From: Anita Gardner
Sent: 25 January 2019 11:15
To: Planning.Responses
Subject: FW: LU/328/18/PL 90/91South Terrace, Littlehampton
Attachments: 955_90ST_P04 - Amendment Diagram.pdf

From: Anita Gardner [<mailto:Anita.Gardner@arun.gov.uk>]
Sent: 04 December 2018 11:44
To: Edmund T. Green [REDACTED]
Subject: LU/328/18/P [REDACTED]

Drawing Number:	955_90ST_D104	Revision:	*
Scale:	1:100 @A3	Date:	MAY 2018
		Drawn:	ETG

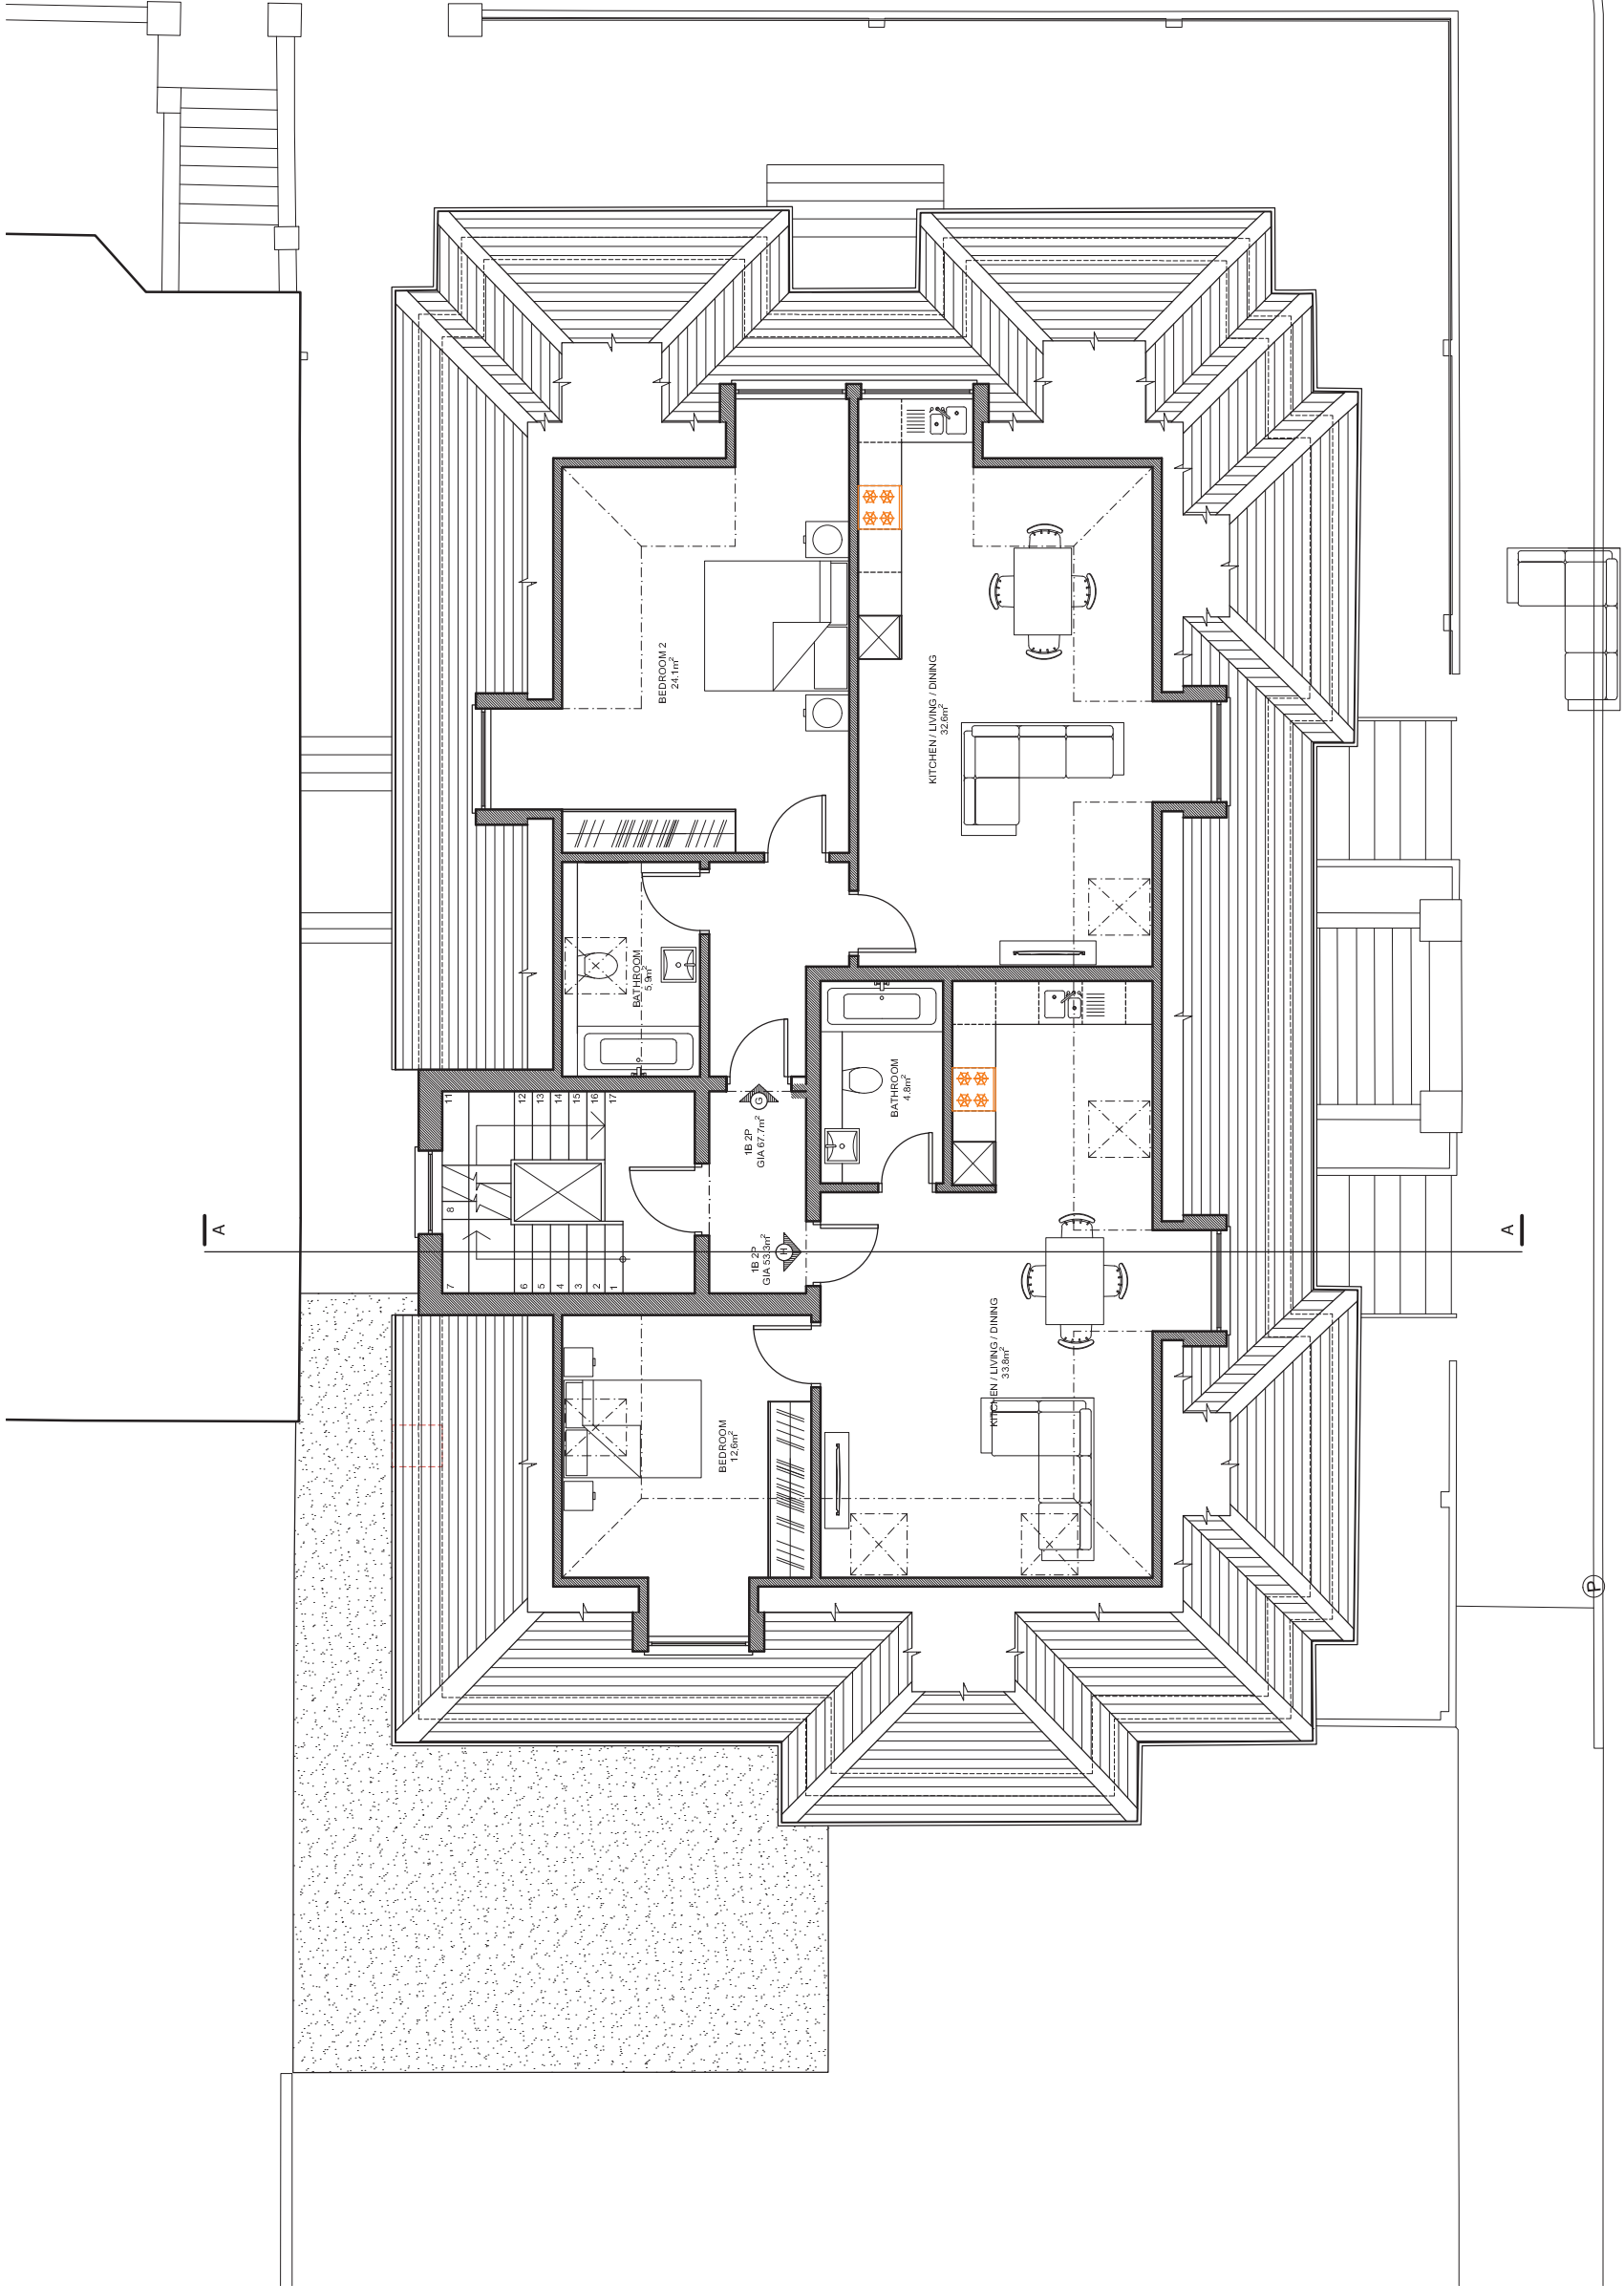
It is noted that the North Elevation Proposed 955_90ST_x010 is incorrectly titled and should read Existing North Elevation and the Second Floor Plan refers to the bedroom to Flat G as the second bedroom when it is the only bedroom.

Please find the amended drawings attached showing the drawing title/labelling errors corrected - thank you for drawing these to my attention.

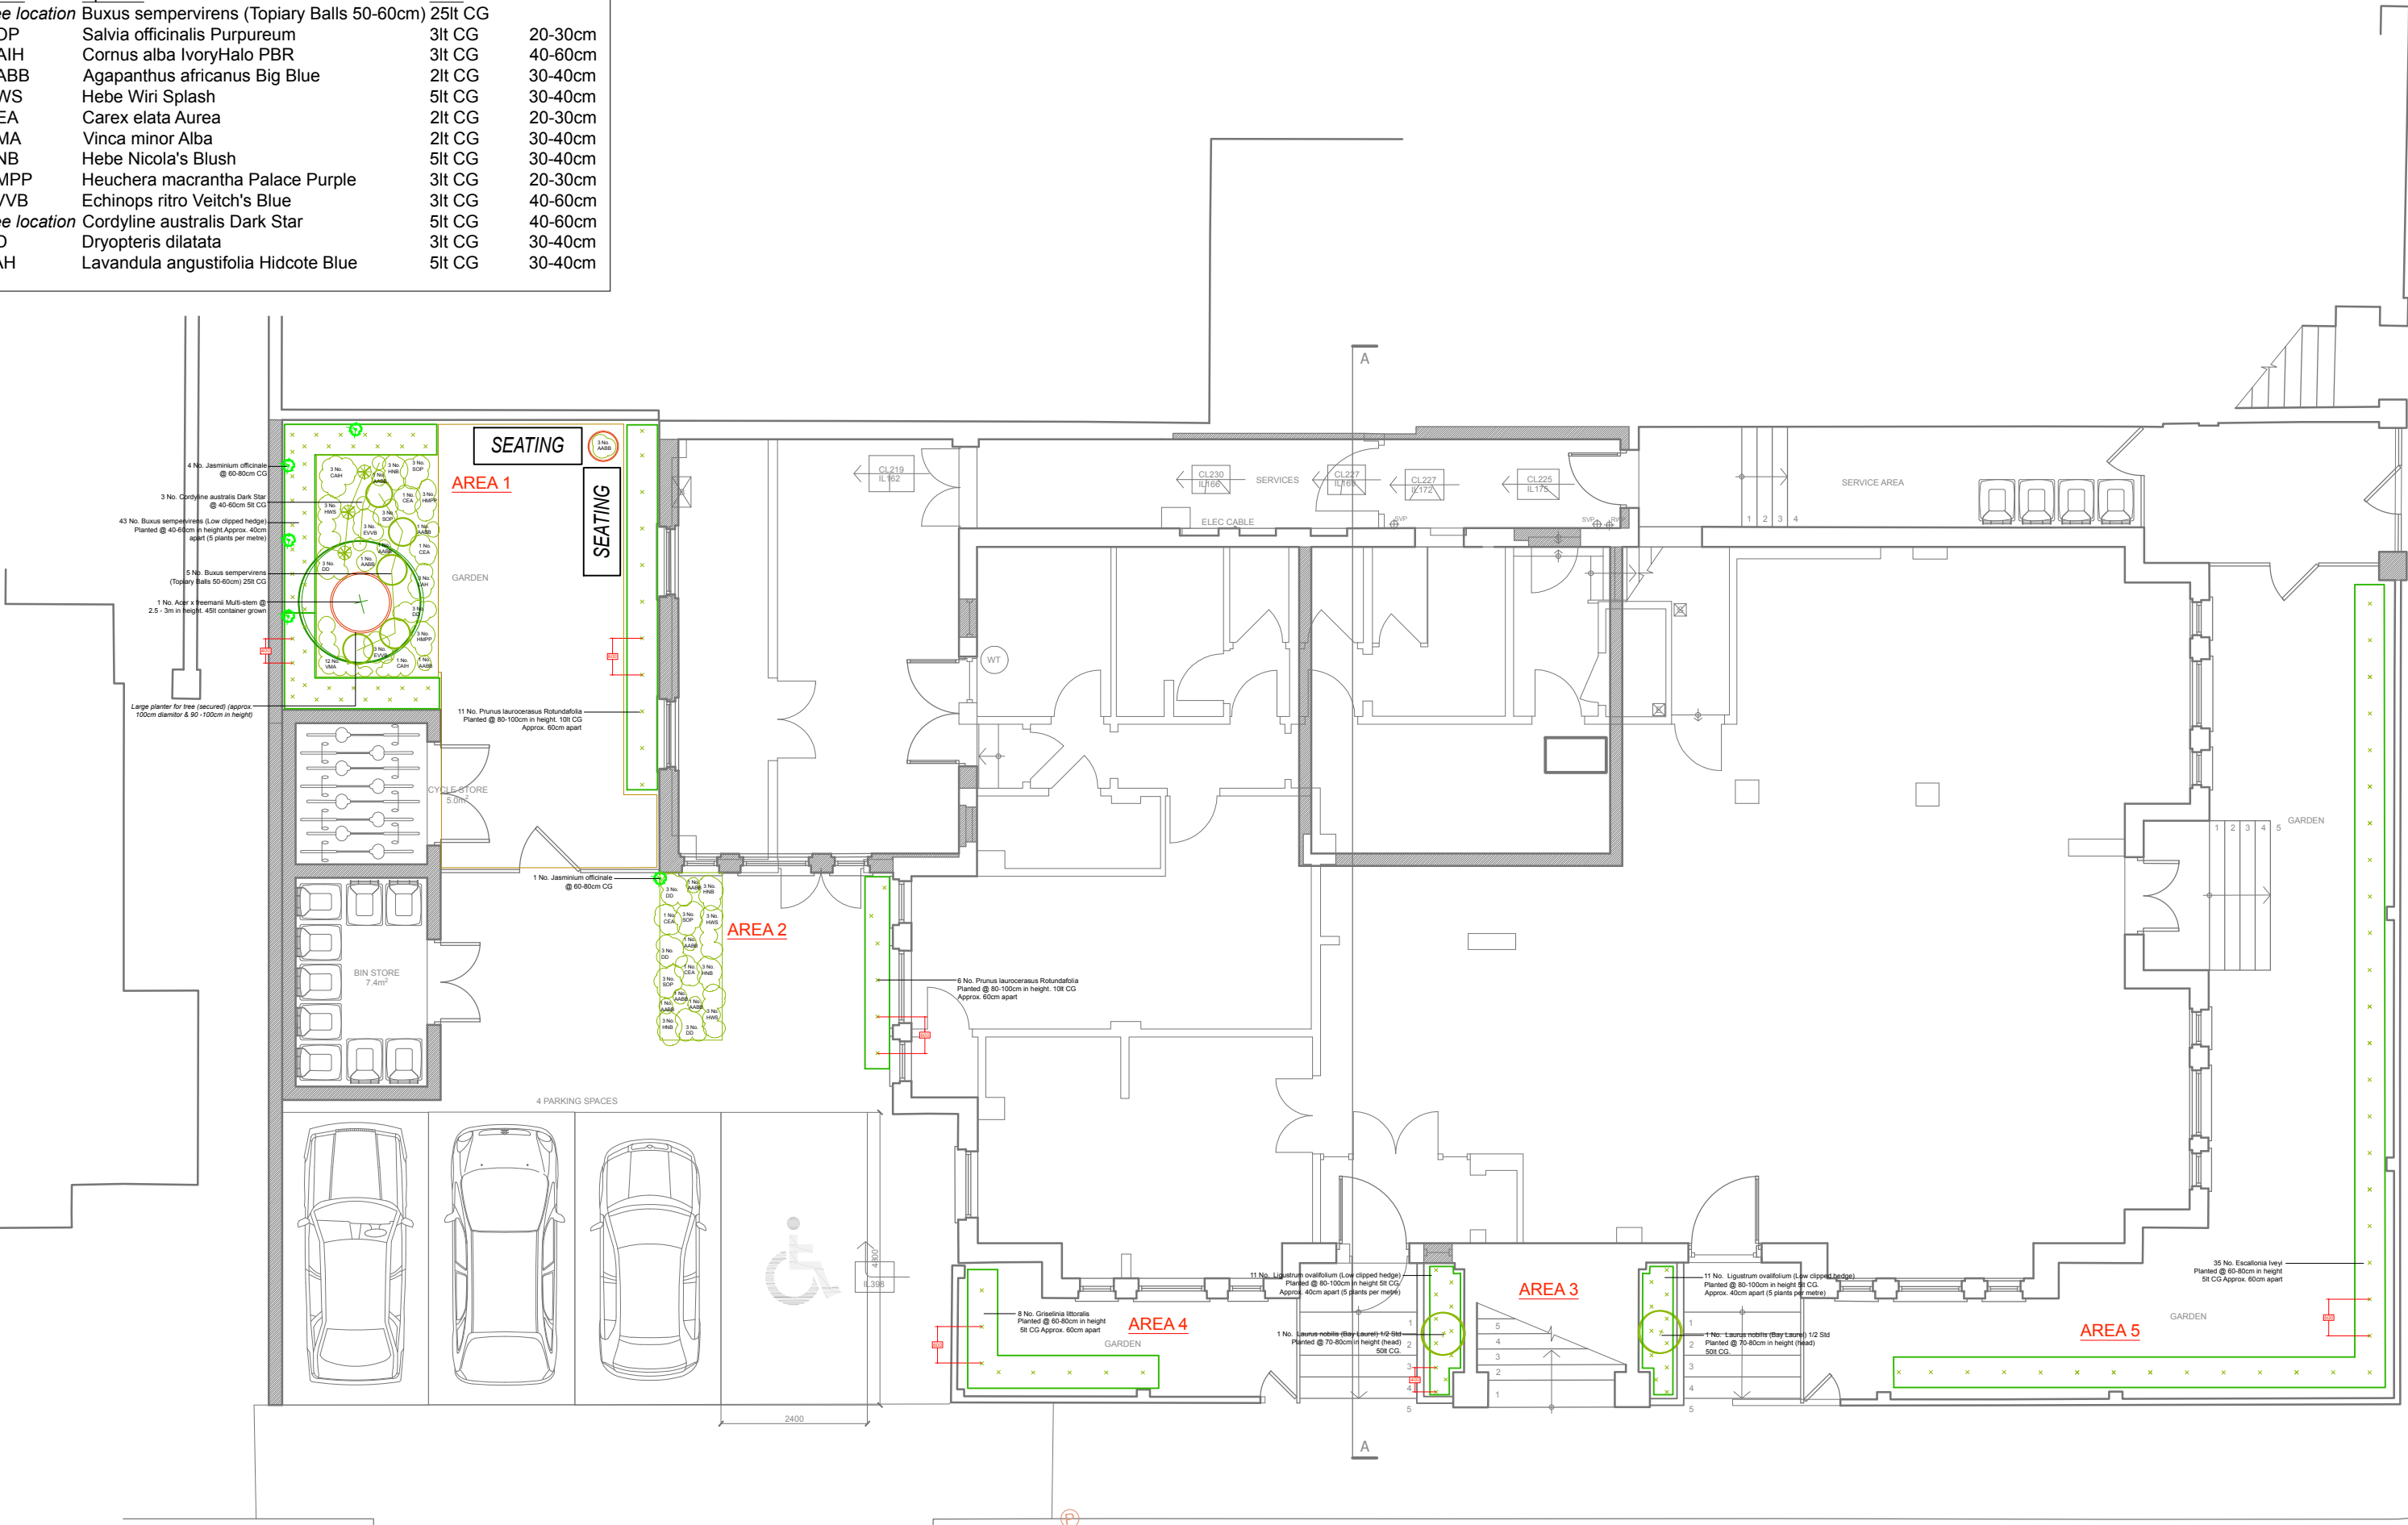
Please can you indicate the railings on the landscaping layout plans and the street scene

I hope you are well. Please find the attached revised landscaping scheme showing the railings as requested. Please confirm receipt of the attached.
